From: Amanda Scholes
Sent: 09 March 2012 14:20
To: Planning.Responses
Subject: FW: FG/16/12 - Minor Material Amendment - Asda (Country Fayre), Littlehampton Road, Ferring.
Attachments: Compack8 brochure new.pdf; Flexy II PCA 0208.pdf

Proposed Roof Plan

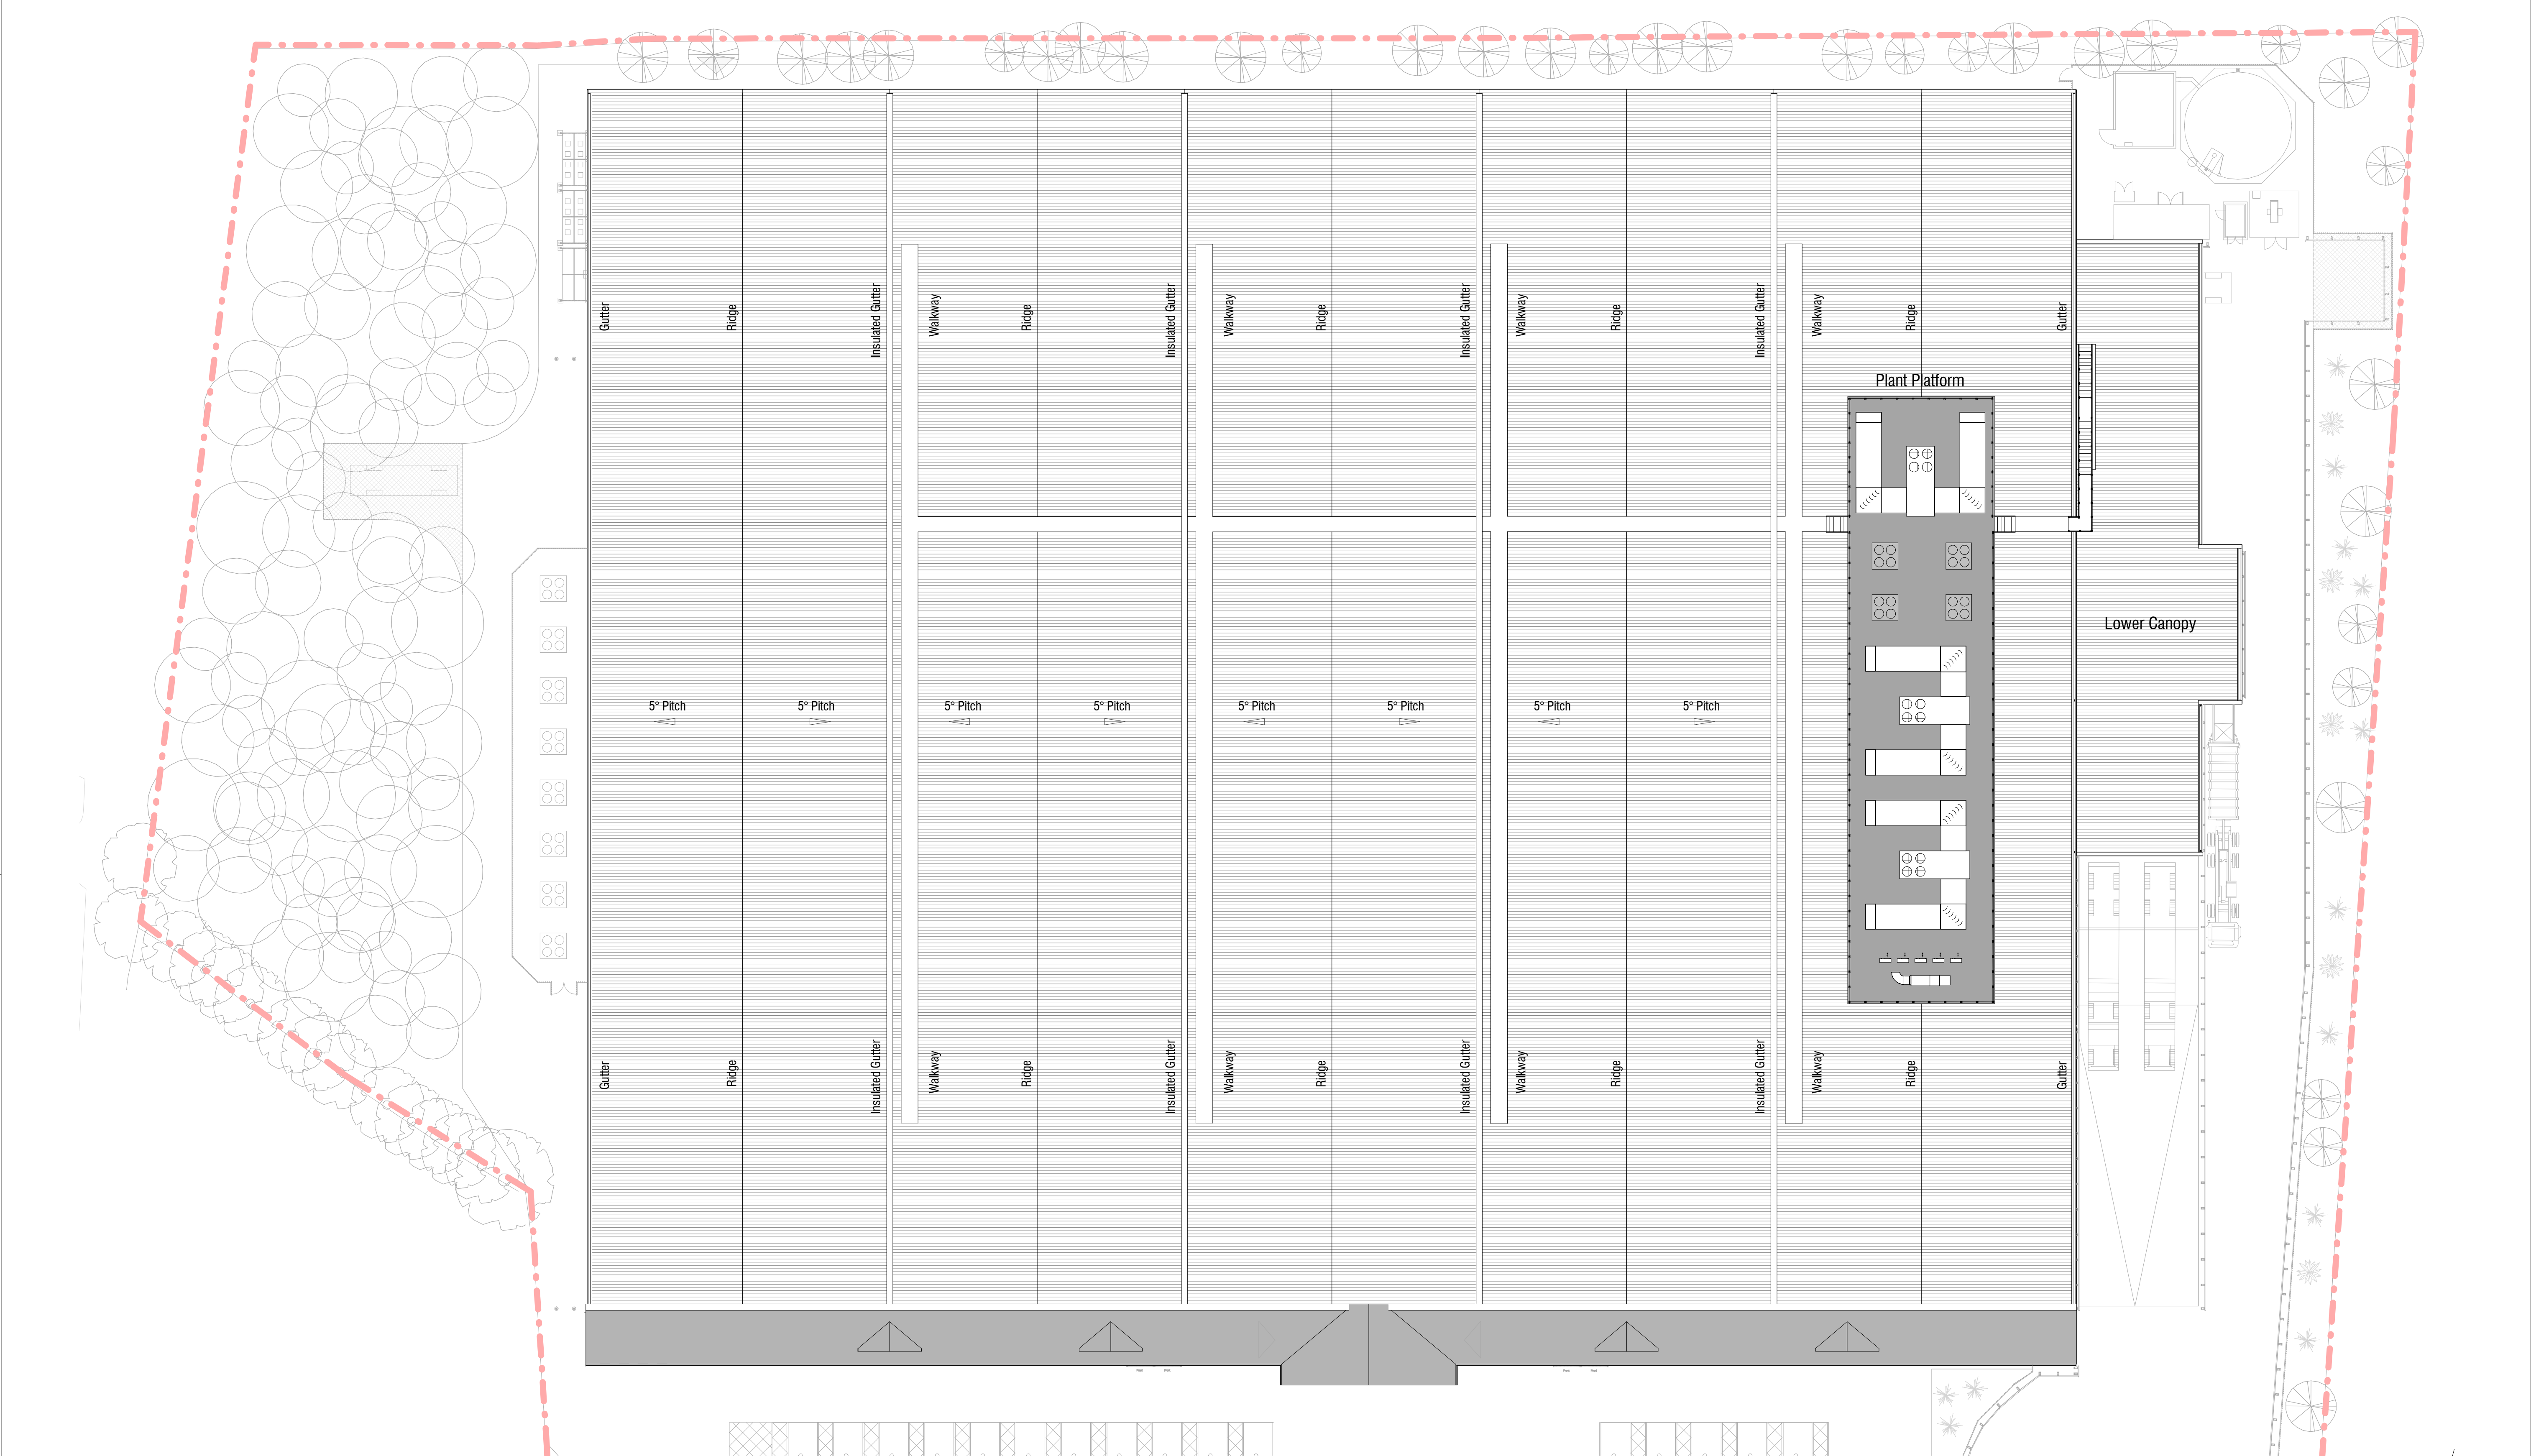
Another matter that has been raised a few times is Legionnaires Disease from the air conditioning/refrigeration plant. Can you please confirm that they do not include a water cooling tower or evaporative condenser.

No information is provided in respect of noise produced by the plant, existing background noise levels, or predicted noise levels at nearest sensitive premises, so definitive comment is not possible. It is noted that the scheme does not propose any screening to either plant compound. I did consider the the potential impact of noise from plant and in view of the separation distance to the nearest sensitive residence ("Huntley" @ 100m+) I did not consider that noise from modern, well maintained plant at this distance was likely to be significant. Noise arising on this site may have a greater impact on future sensitive development in closer proximity and may be a consideration in any application for such development.

You have responded to the above thank you, but I have been asked to check that you have considered both the air conditioning units on the roof together with the refrigeration plant on the east side of the supermarket and the pump room etc. on the west side of the building, particularly with regard to the surrounding residential properties.

With regard to the question on Legionnaires Disease we can confirm that the cooling for the air handling plant is air-cooled. There is a sealed heat reclaim system that utilises a water/glycol solution as a heat transfer medium. It is used to recover waste heat from the HT/LT pack for use in pre-heating domestic hot water. There are no cooling towers, or condensers that use evaporative cooling.

The proposed refrigeration plant is designed on dry air cooled condensers and does not include a water cooling tower or evaporative condensers.
